City of Albuquerque

June 19, 2003

RE: Low Wallace Addition Grading and Drainage Plan (J14-D37)
Engineer's Stamp Dated June 3, 2003

GRADING and DRAINAGE PLAN

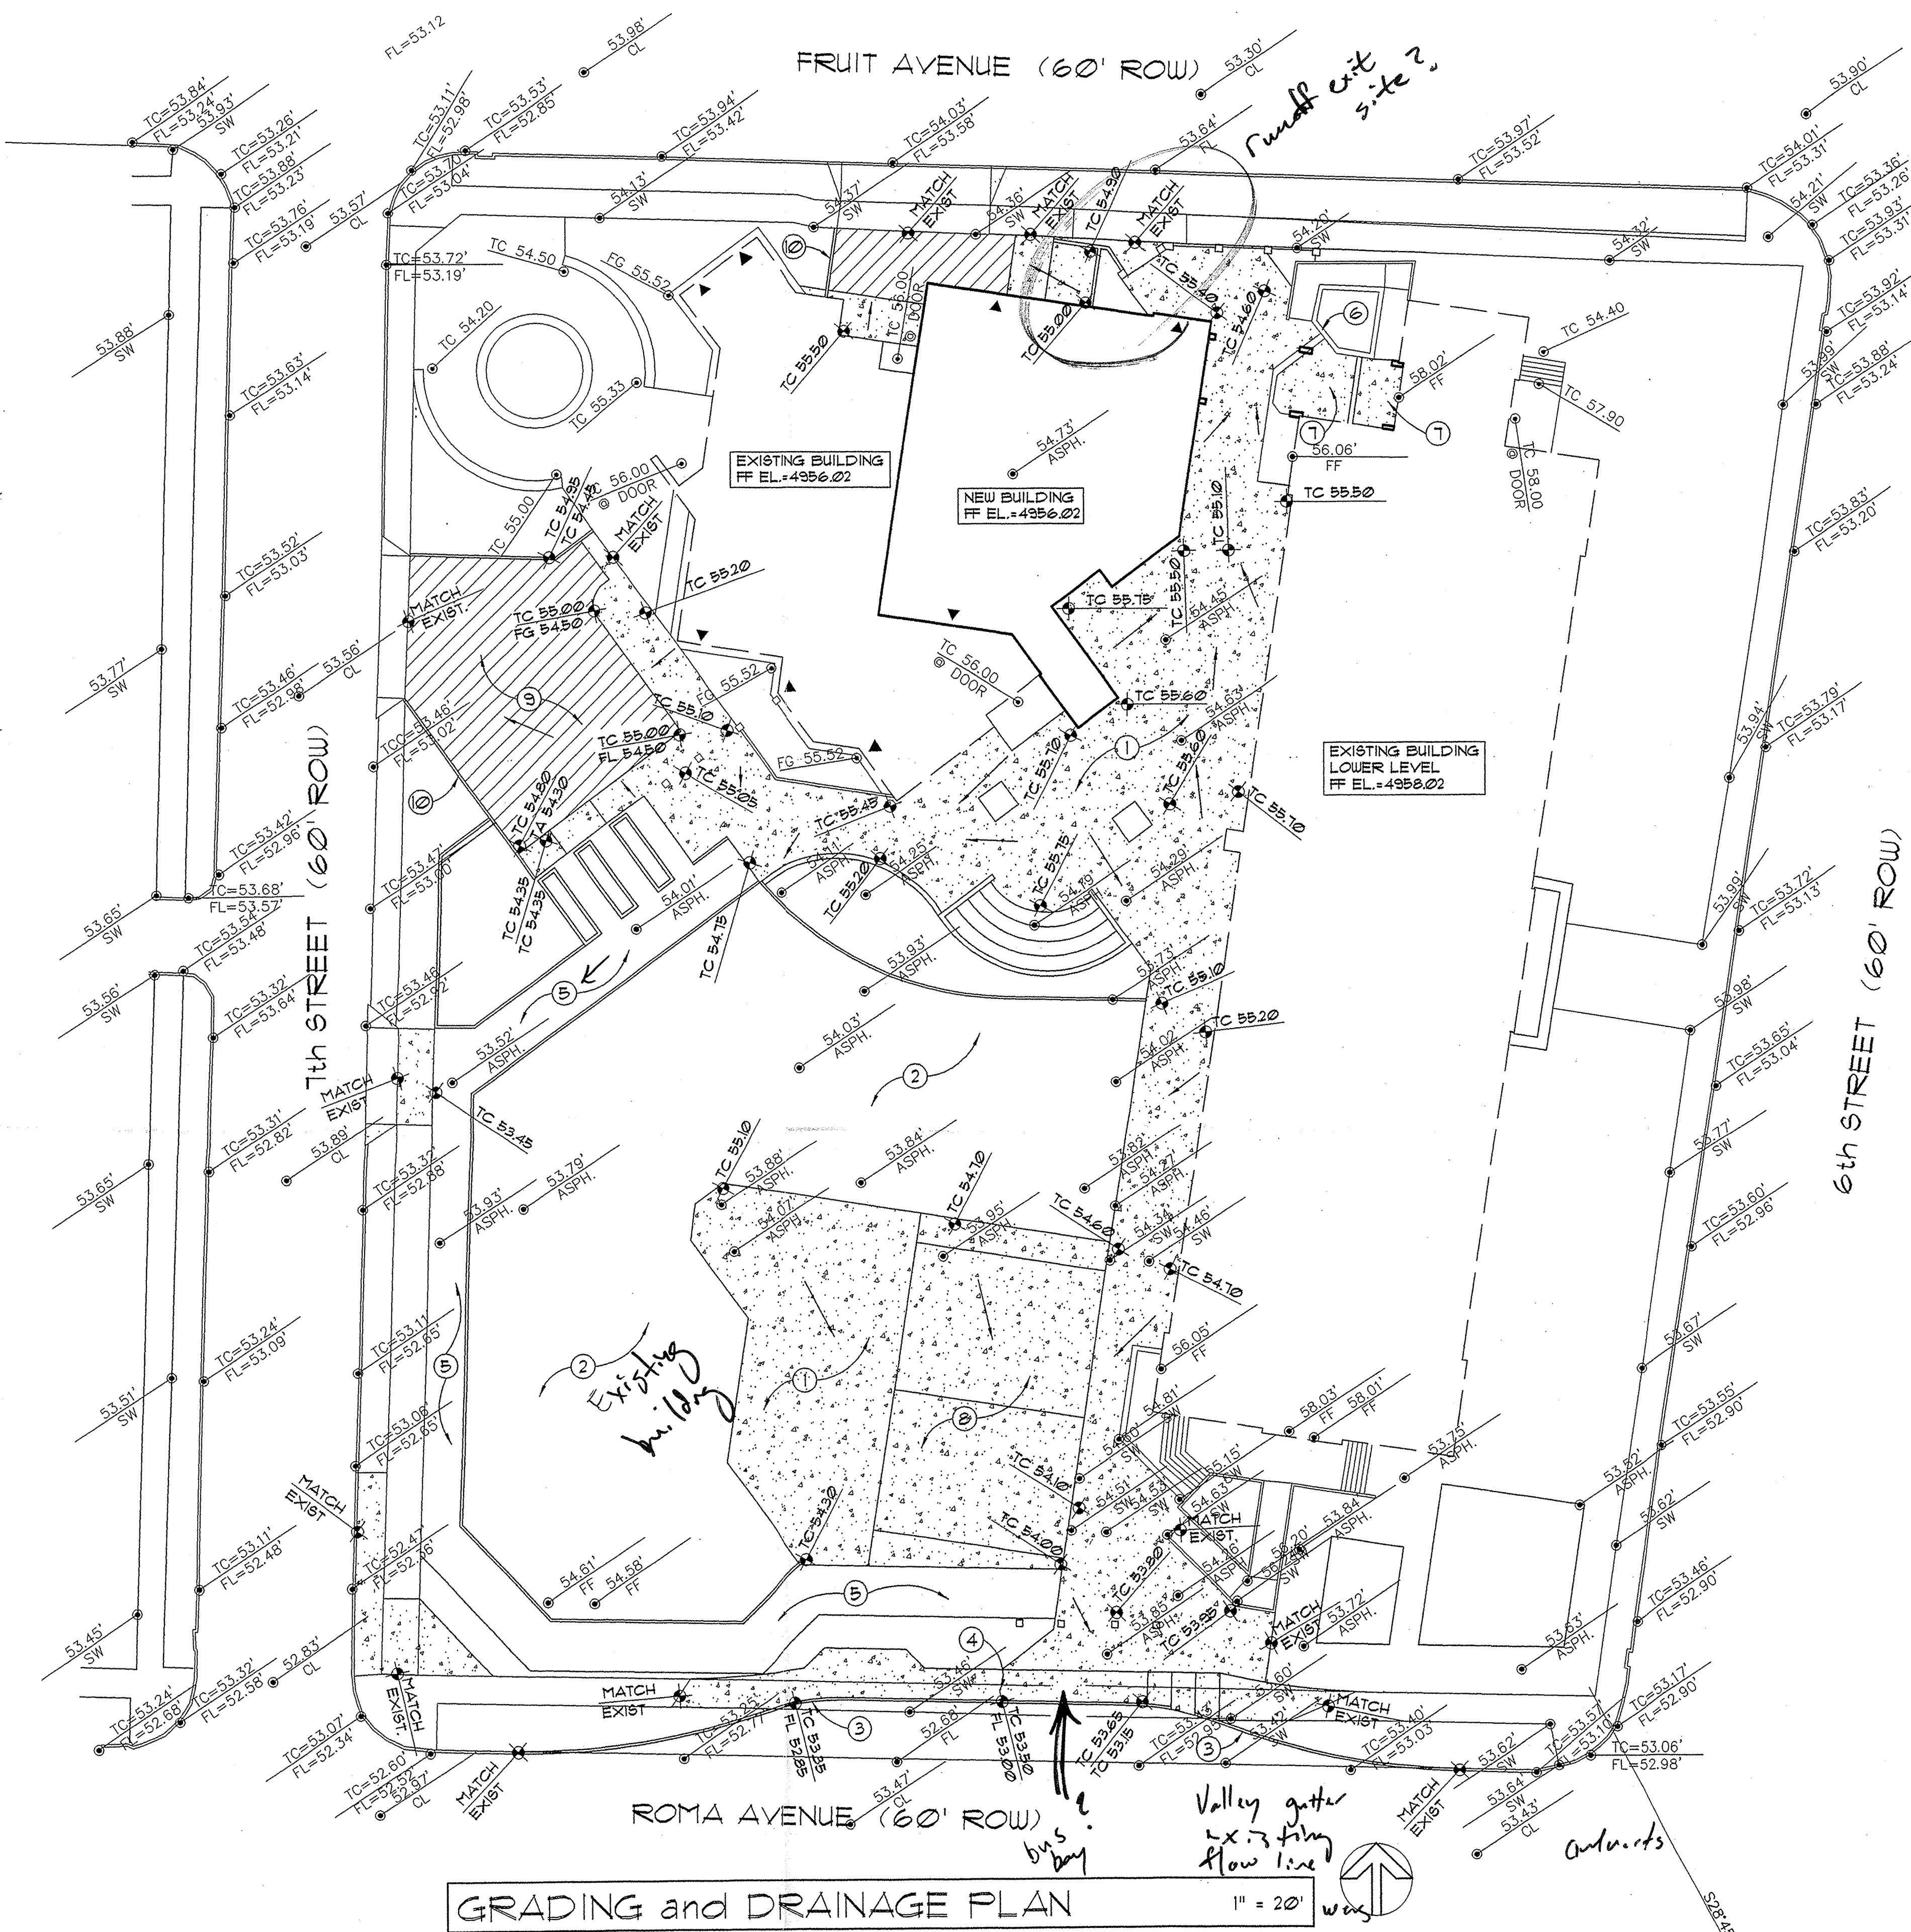
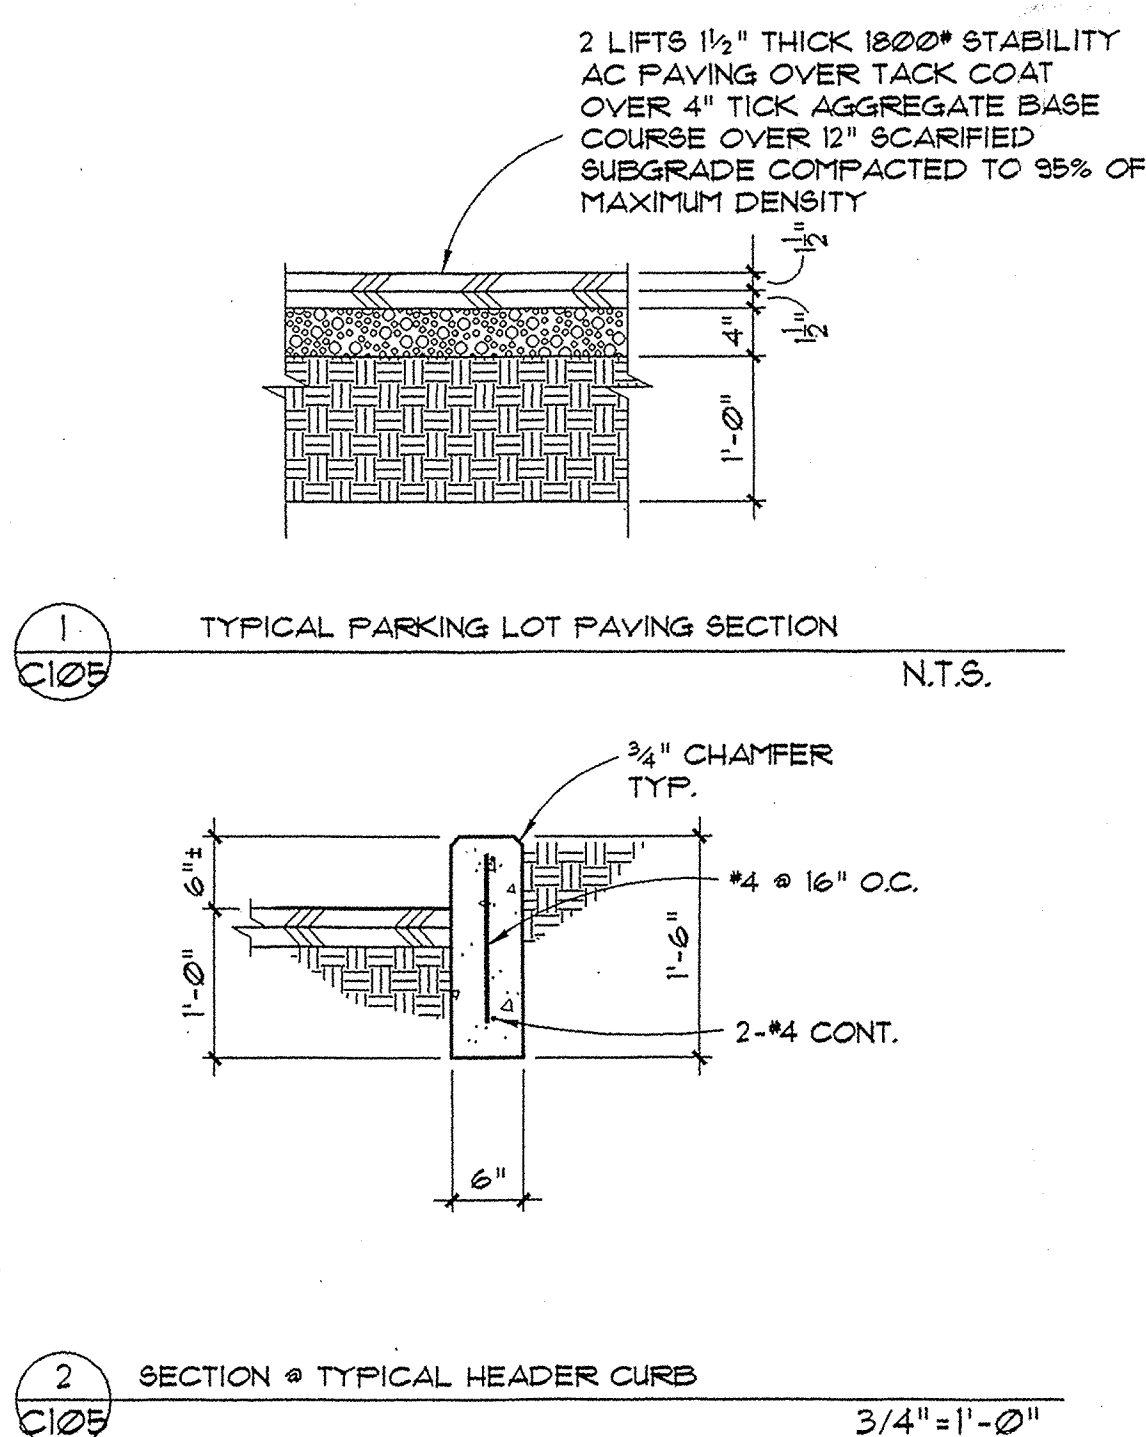
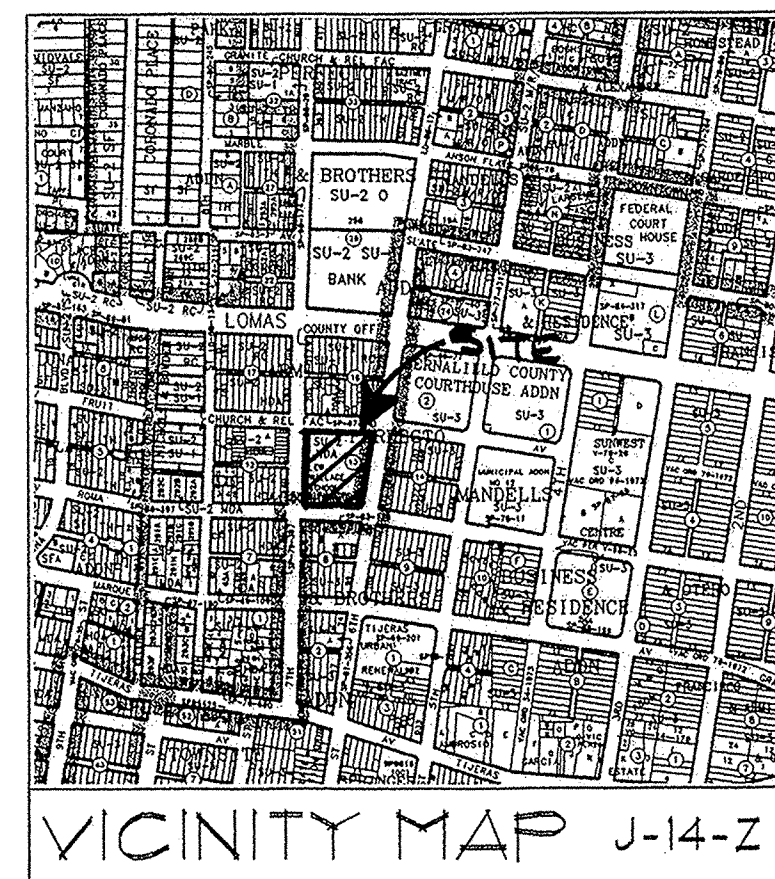
- Please show a bus bay valley gutter where the existing flow line is.
- Please provide a cross-section of the valley gutter.
- Due to safety risks the City does not allow runoff to drain over sidewalk. Please use culverts to drain runoff onto Fruit Ave. and Roma Ave. Sidewalk culverts require an SO#19, please submit two copies of plan and provide all applicable notes and signature blocks.
